Our Ref: LU/414/17/PL
Your Ref:

Development Change of use of lower ground floor restaurant (A3 Food & Drink) to shop (A1 Shops), demolition of existing garage, conversion of shop & residential space to provide 6 No. one bedroom flats (five additional units) to include first & second floor extensions & stairtower (resubmission following LU/71/17/PL & LU/243/17/PL).

Location 56-57 Pier Road Littlehampton

Drawing Title
Proposed Drawing
Lower and Upper Ground Floor Plans
1/100 @ A3

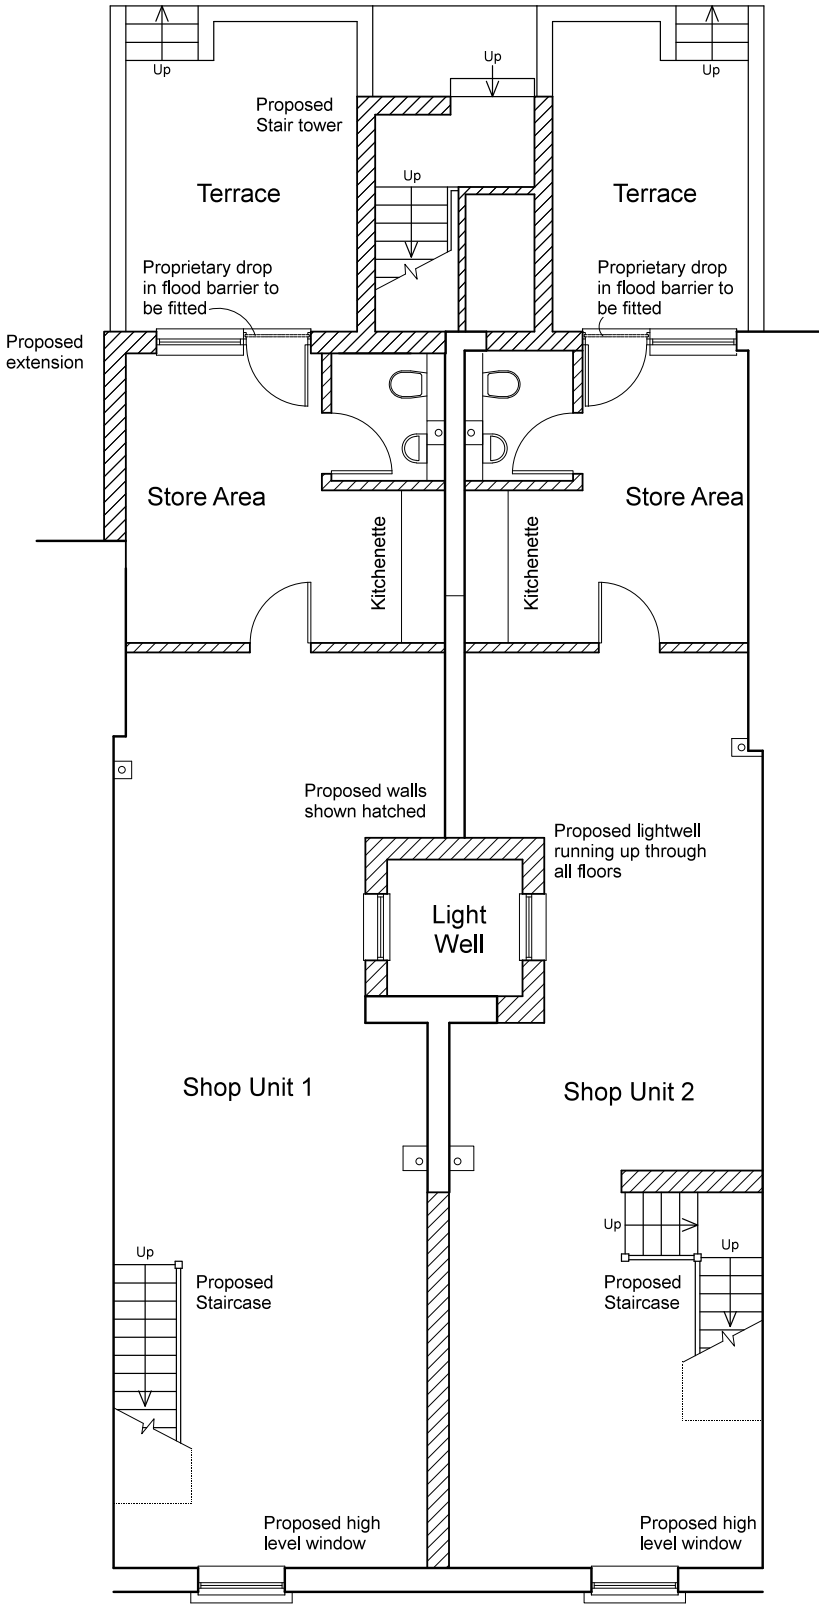
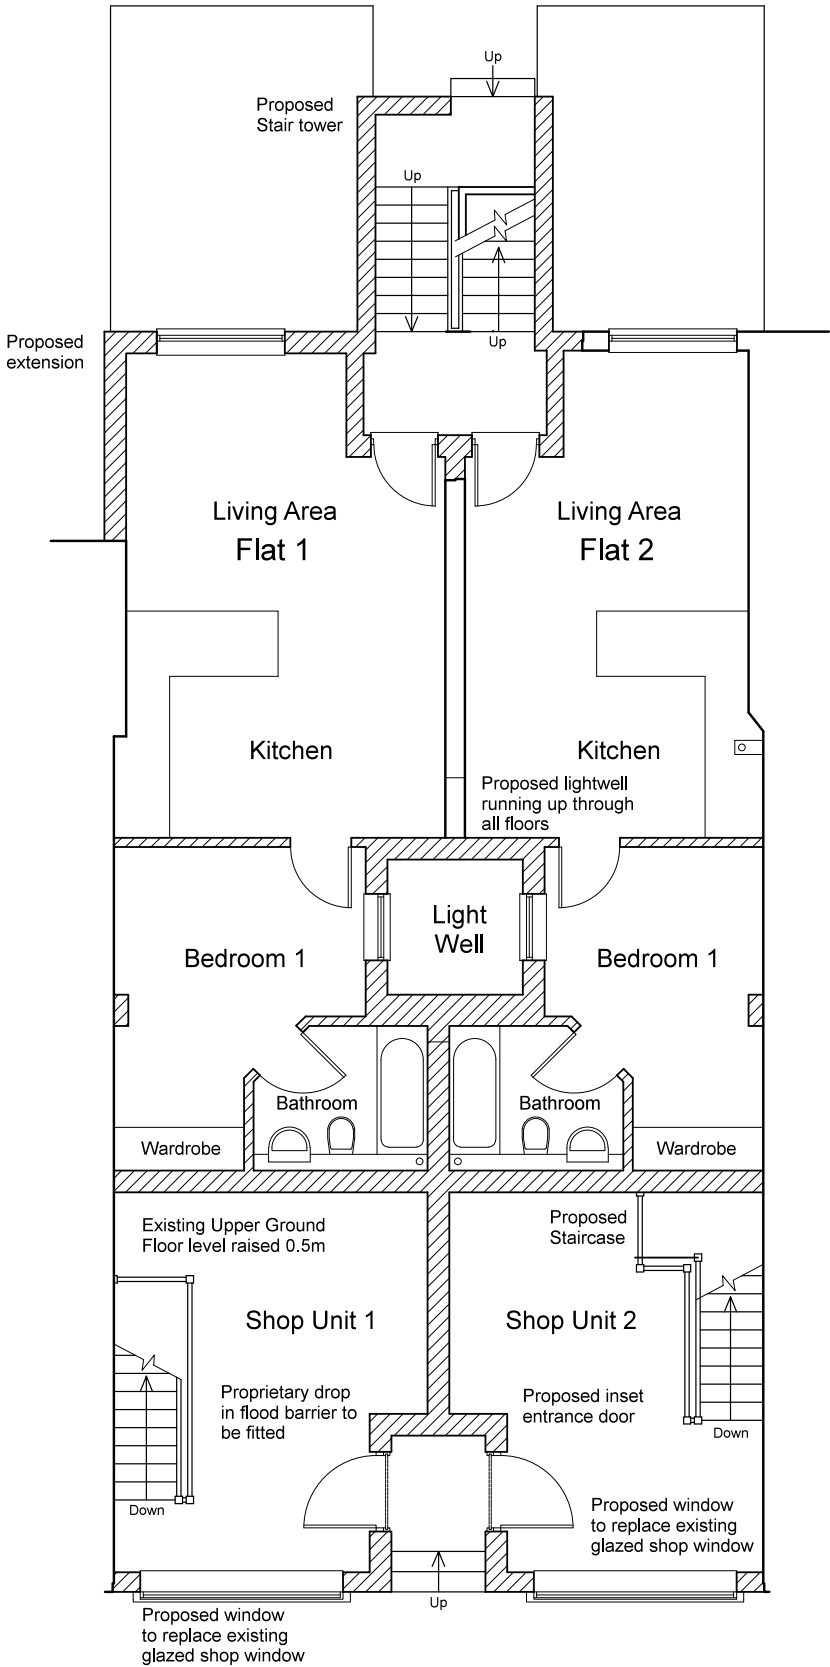
The proposed north and south upper ground floor plans and elevations do not accord. Please amend accordingly.
